From: [REDACTED]
Sent: 15 March 2019 13:06
To: Stuart Corbey
Cc: Nicola Fry; Juan Baeza
Subject: RE: LU/182/18/PL - 46A & 46B Pier Road

TO:	Arun District Council FAO: Stuart Corbey
FROM:	Highways, WSCC
DATE:	12/02/2019
LOCATION:	46a and 46b Pier Road, Littlehampton, BN17 5LW
SUBJECT:	LU/182/18/PL Demolition of the existing buildings and erection of 2 No. new buildings incorporating commercial (A1) at ground floor with 4 No. new residential units above.
DATE OF SITE VISIT:	20/09/2018
RECOMMENDATION:	
S106 CONTRIBUTION TOTAL:	£N/A

Proposed site plan Scale 1:200 @A3

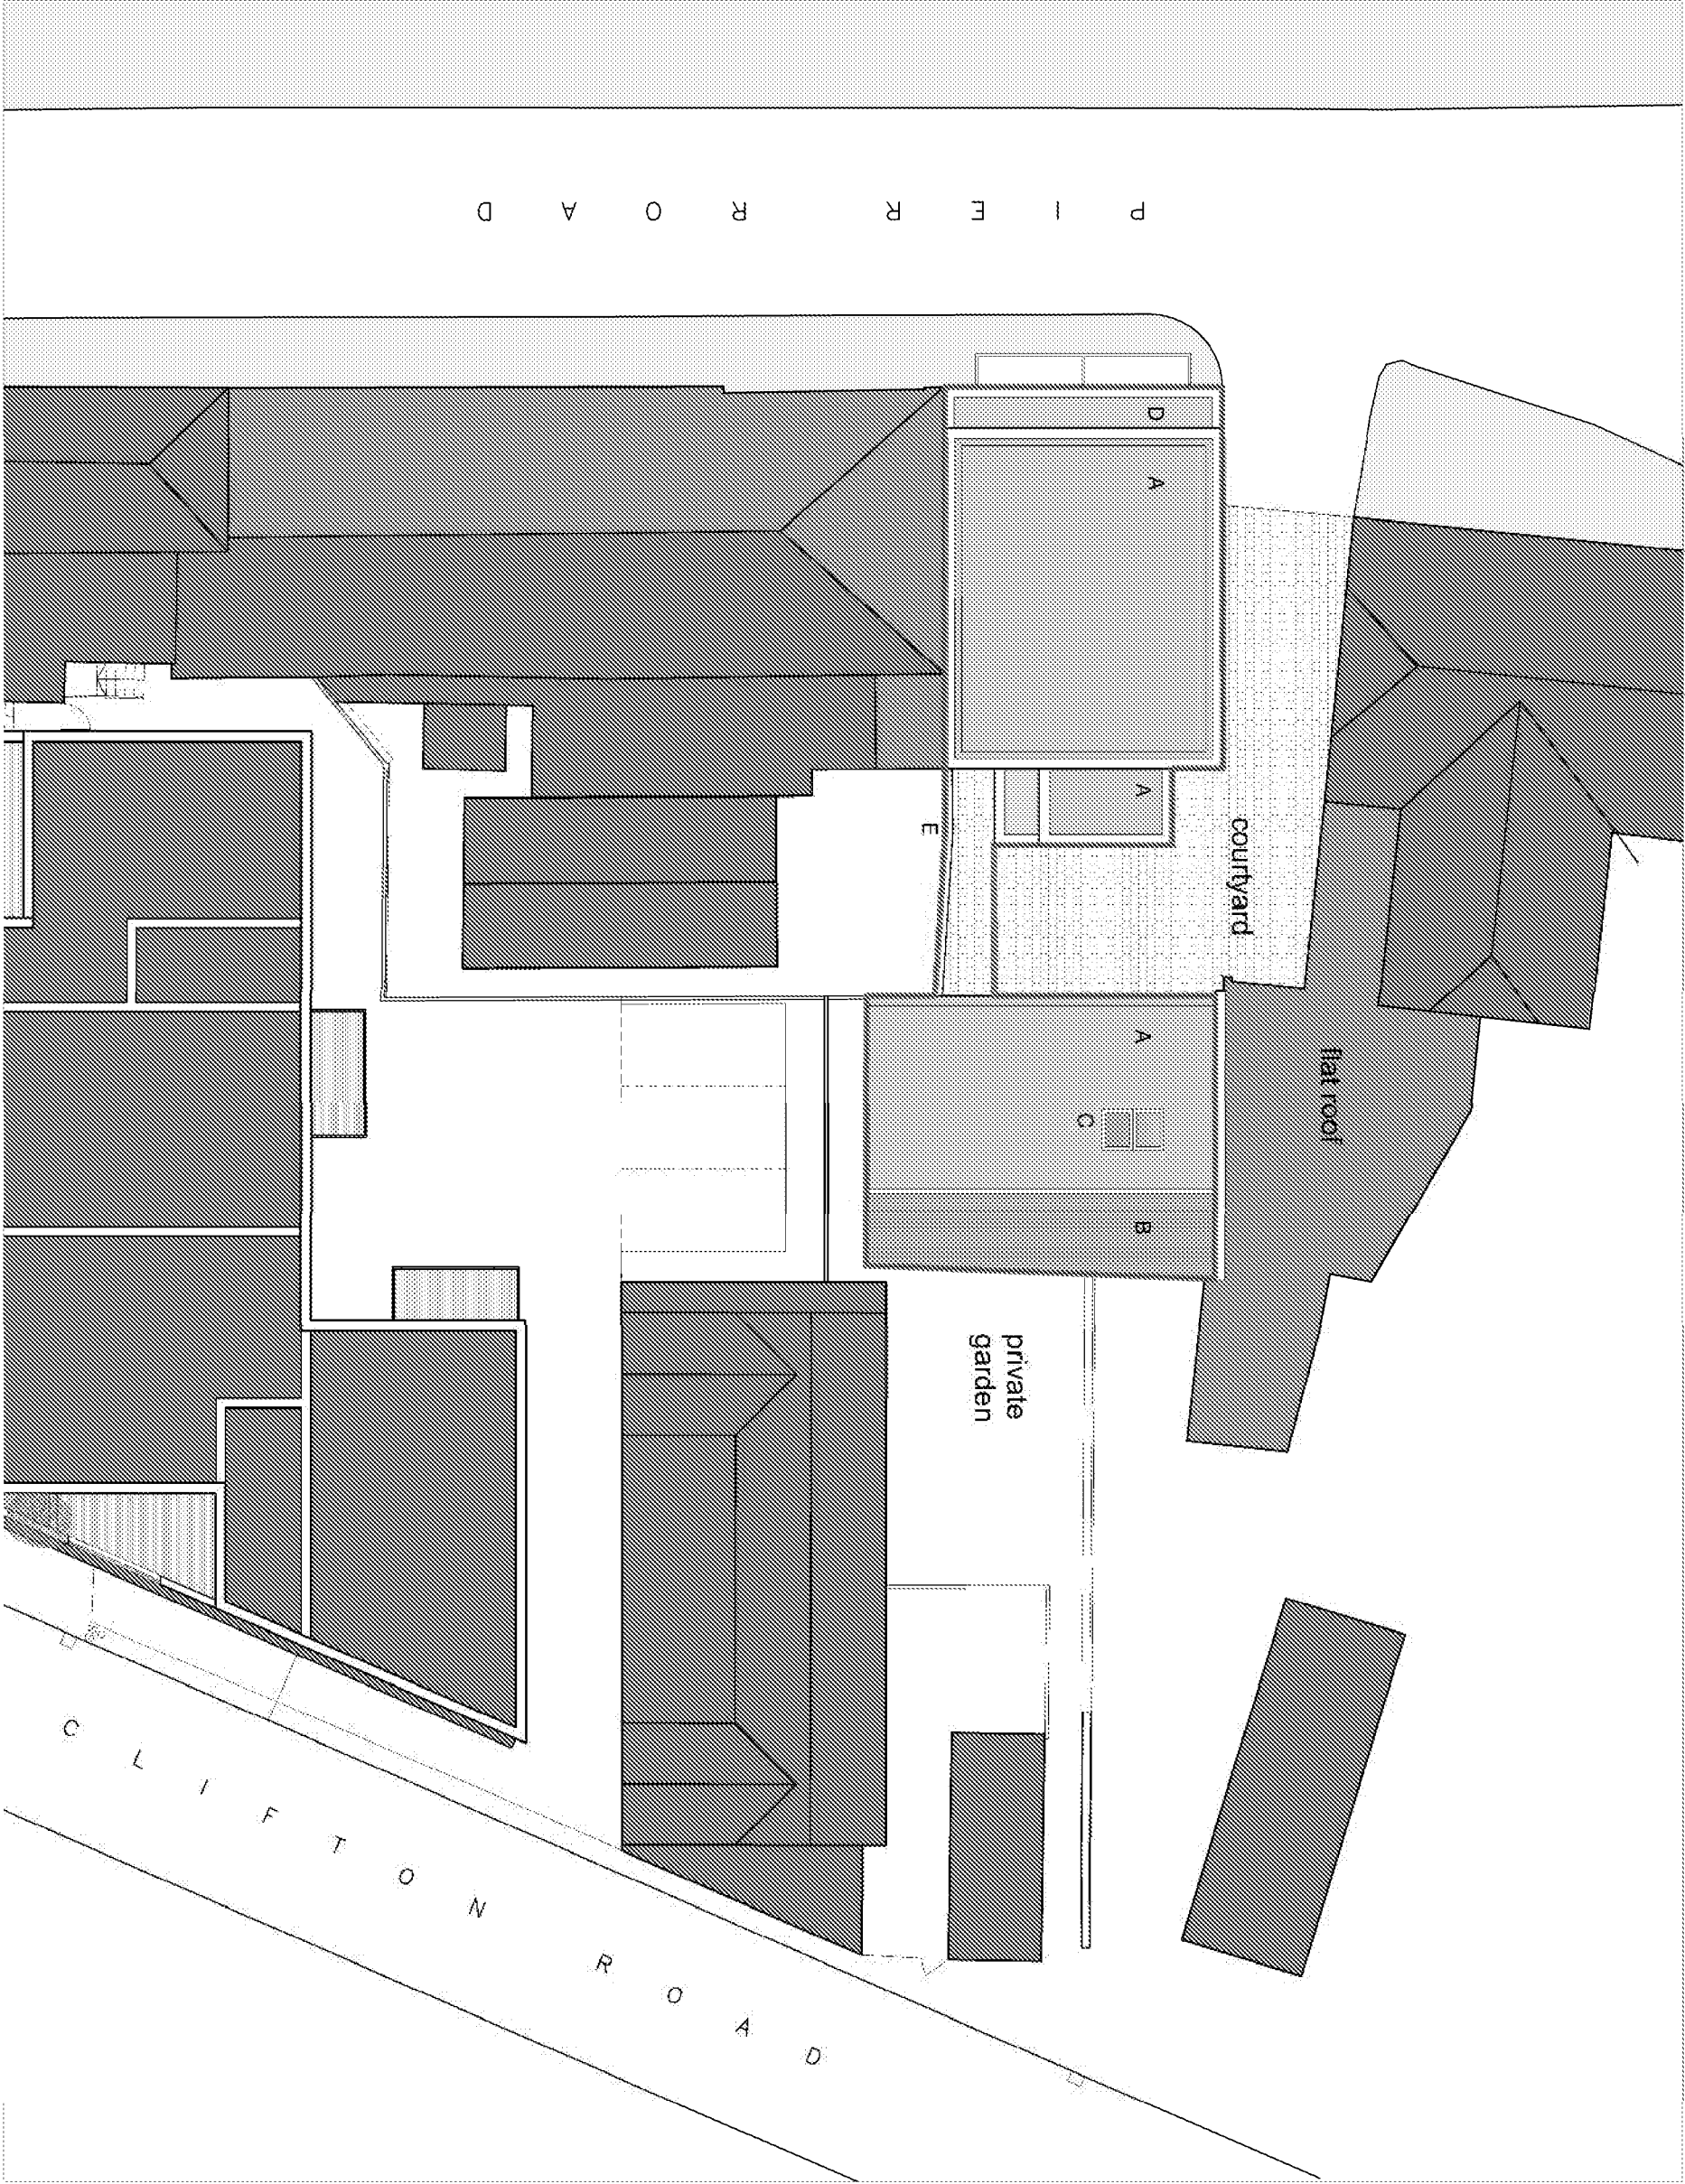
The applicant was requested to provide maximum achievable visibility splays at a 2m X distance. Manual for Streets (MfS) sets out a minimum sight stopping distance of 43m for a 30mph road. The revised plans demonstrate maximum achievable visibility of 2m x 32m to the north and 2m x 12.5m to the south. Visibility to the south has been demonstrated as severely substandard for the anticipated road speeds. A reduction in visibility splays can be accepted when a speed survey has been conducted demonstrating 85th percentile speeds in accordance with the achievable visibility splays. A speed survey has not been undertaken to support visibility splays of 12.5m to the south of the access. Visibility splays of 12.5m would equate to road speeds of 11mph - the LHA does not anticipate that vehicles would be travelling at these speeds in this location.

The applicant proposes to provide three covered parking spaces for the residential use. The applicant was previously requested to provide swept path tracking in order to demonstrate that vehicles can manoeuvre in and out of the proposed spaces and turn on site in order to exit onto the public highway in a forward gear. The applicant has not provided swept path tracking and as such has failed to demonstrate that vehicles can turn on site. The LHA would not support vehicles reversing onto the public highway in this location due to the severely substandard visibility at the access.

In conclusion, the LHA considers that the applicant has not demonstrated safe and suitable access for the proposal. The application is anticipated to result in a material intensification of use of a substandard point of access and would result in an unacceptable impact on highway safety contrary to paragraph 109 of the National Planning Policy Framework. **The applicant is advised to consider providing a nil parking provision for the development.**

Following our conversation yesterday I have had the opportunity to speak with Ian Hayward who saw the site with Nicki in September 2018. The site does have an access which is substandard and our comments to that are still considered accurate. However what has changed since our consultation response dated the 12th February is confirmation from the applicant that the site has been used by a number of vehicles in the past and we accept that this could have occurred at any one time. The information has to be taken in good faith and accurate. In addition to the above we have undertaken a check on the accident records at the proposed point of access onto Pier Road, an investigation of this suggests there have been no recorded accidents in the last 10 years, this confirms there have been no accidents in relation to the proposed use of access point.

Therefore based on the information provided by the applicant we would accept that there is unlikely to be any material change to the traffic patterns as a result of the application and on that basis not raise an objection to the proposals.
